PLACE AND GROWTH INTERNAL MEMORANDUM

APPLICATION FOR PLANNING PERMISSION PLANNING POLICY CONSULTATION RESPONSE

Planning Application No.	18/00825/HYBRID
Address / Location	Heyford Park Camp Road Upper Heyford Bicester OX25 5HD
Proposal	Demolition of buildings and structures as listed in Schedule 1; Outline planning permission for up to 1,175 new dwellings (Class C3); 60 close care dwellings (Class C2/C3); 929 m2 of retail (Class A1); 670 m2 comprising a new medical centre (Class D1); 35,175 m2 of new employment buildings, (comprising up to 6,330 m2 Class B1a, 13,635 m2 B1b/c, 9,250 m2 Class B2, and 5,960 m2 B8); 2.4 ha site for a new school (Class D1); 925 m2 of community use buildings (Class D2); and 515 m2 of indoor sports, if provided on-site (Class D2); 30m in height observation tower with zip-wire with ancillary visitor facilities of up to 100 m2 (Class D1/A1/A3); 1,000 m2 energy facility/infrastructure with a stack height of up to 24m (sui generis); 2,520 m2 additional education facilities (buildings and associated external infrastructure) at Buildings 73, 74 and 583 for education use (Class D1); creation of areas of Open Space, Sports Facilities, Public Park and other green

# HEYFORD PARK - DEMOLITION & CHANGE OF USE PLAN

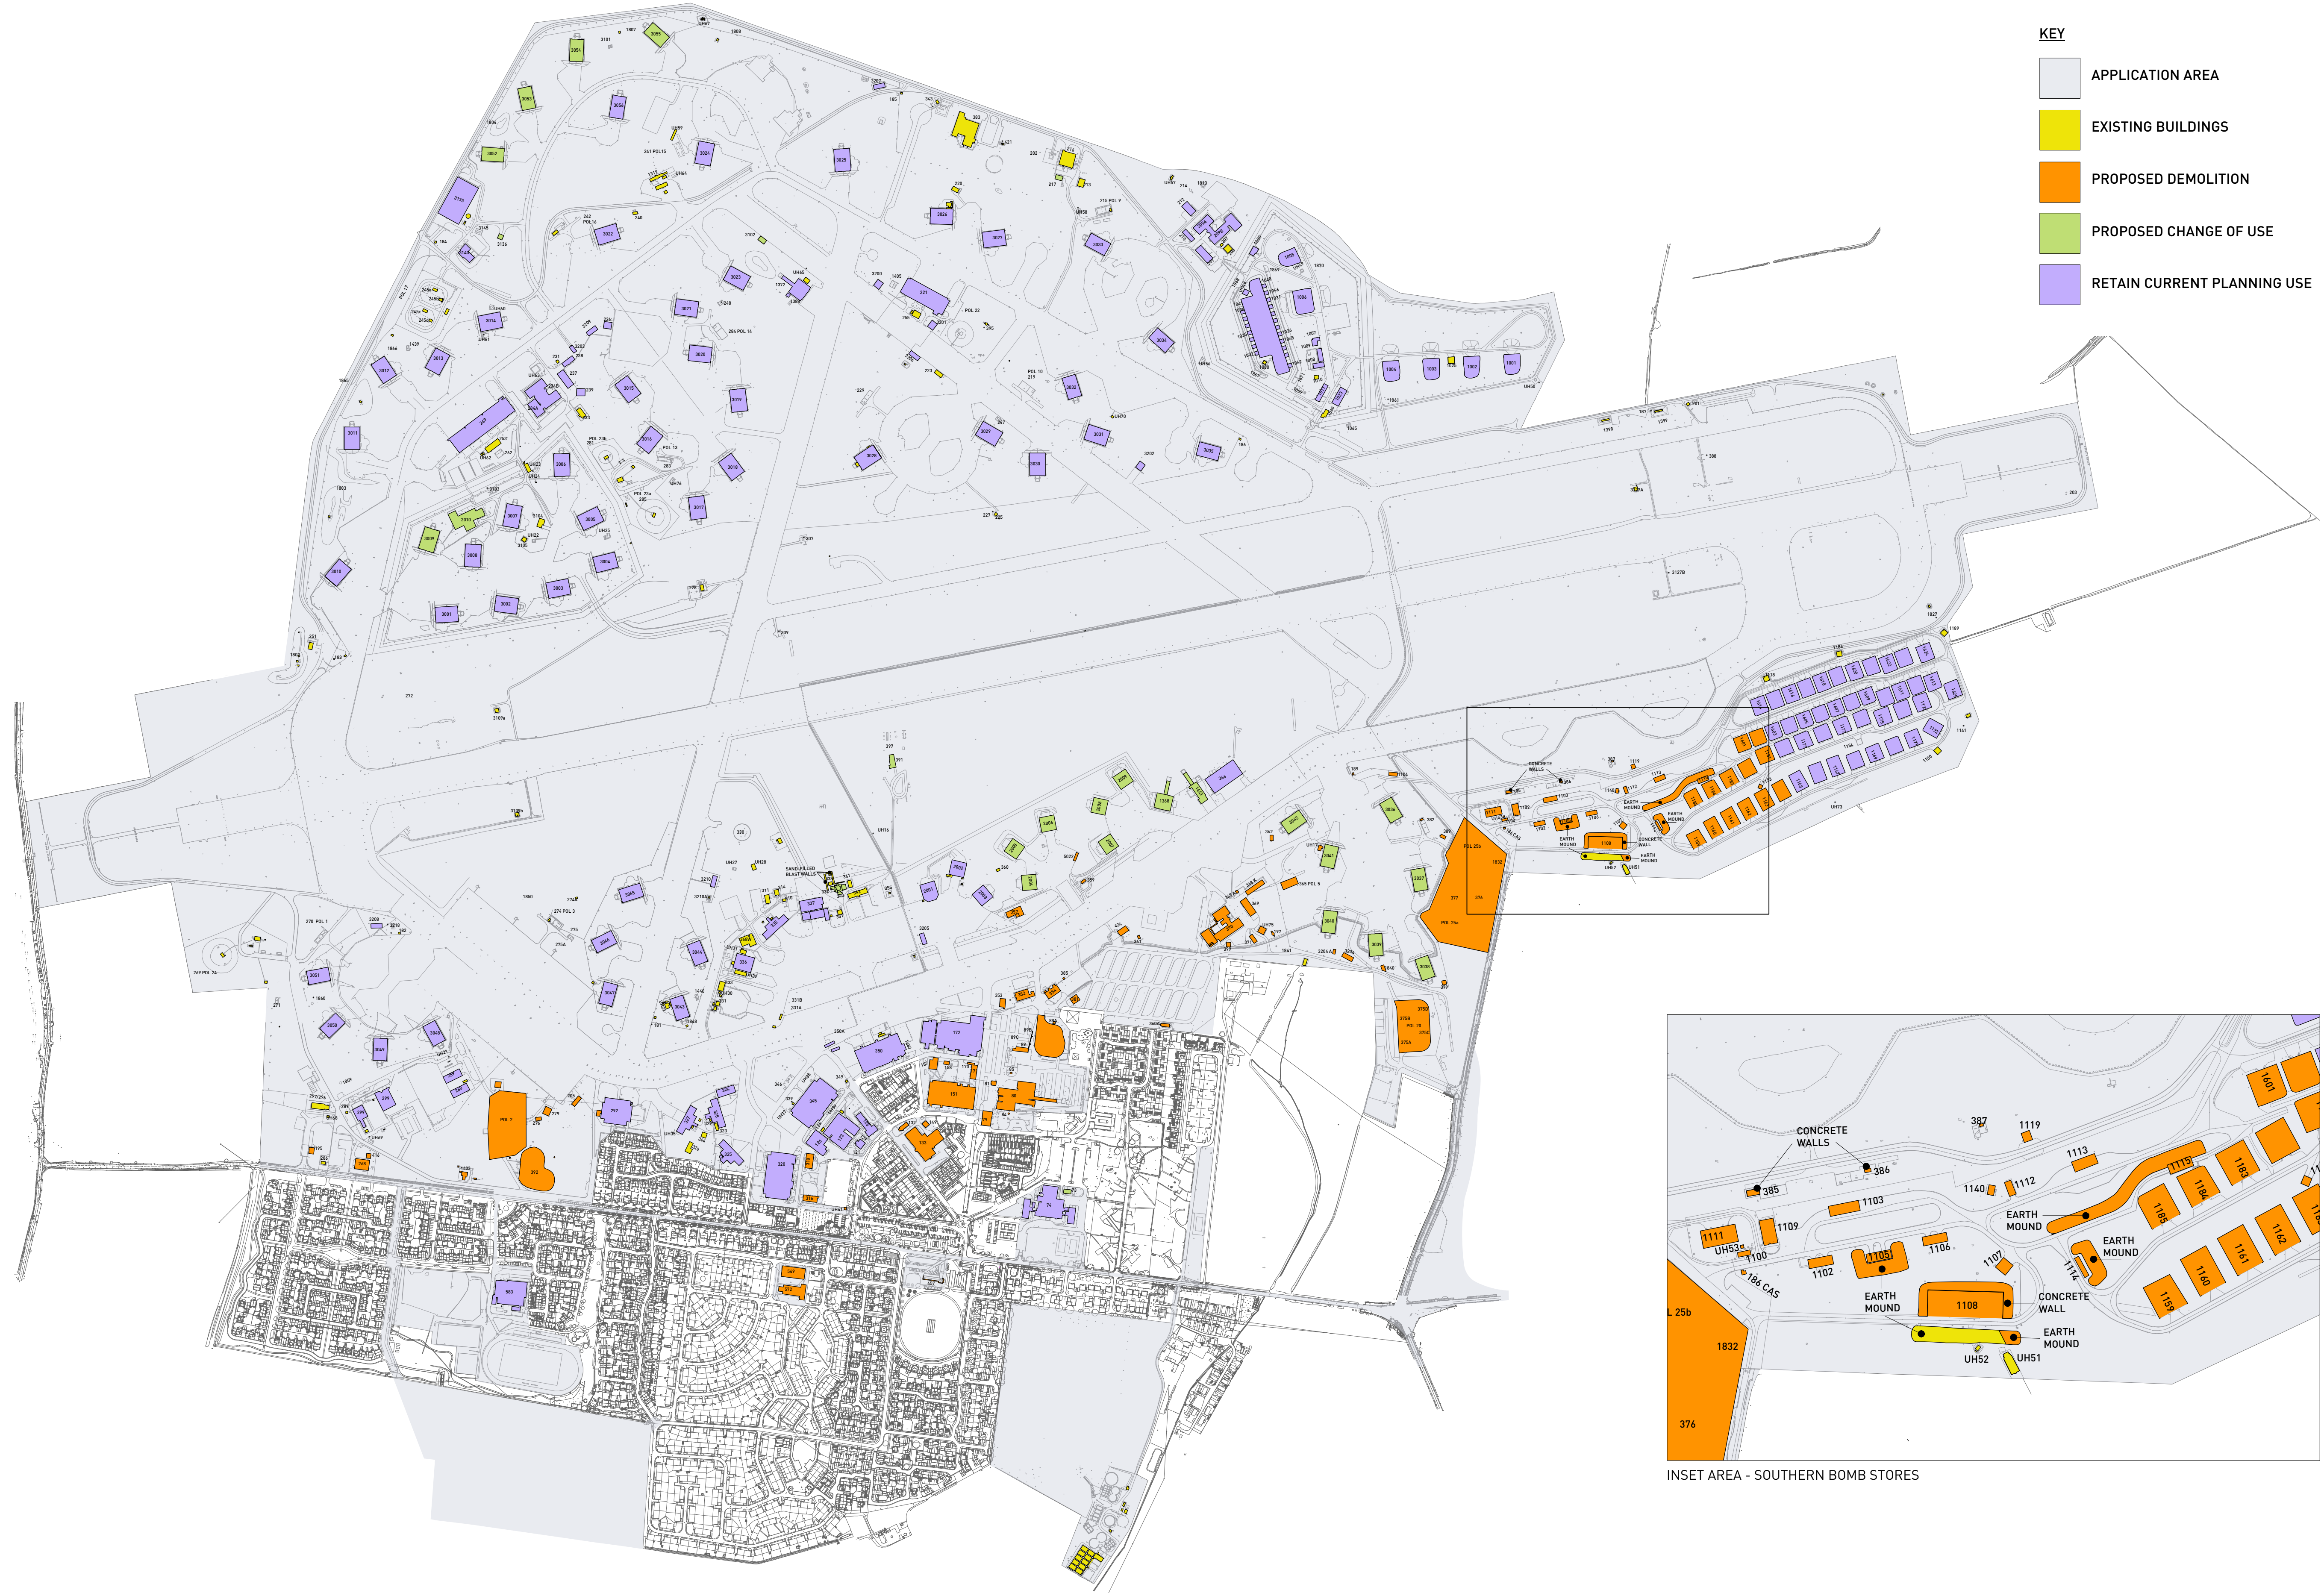
The impact on the Conservation Area caused by the partial loss of the southern bomb stores (Parcel 23) would also need detailed consideration and discussion with Design and Conservation.

The masterplan also proposes the demolition of a number of buildings. This includes the demolition of buildings 315 and 151 to facilitate the provision of a mixed use development and close care facility. These buildings are considered to make a significant contribution to the former character of the airbase. The retention and reuse of these buildings should therefore be explored. Detailed consultation with Historic England and Design and Conservation is advised, especially given the proximity of buildings 315, 316 and 318 to building 126, a scheduled ancient monument.
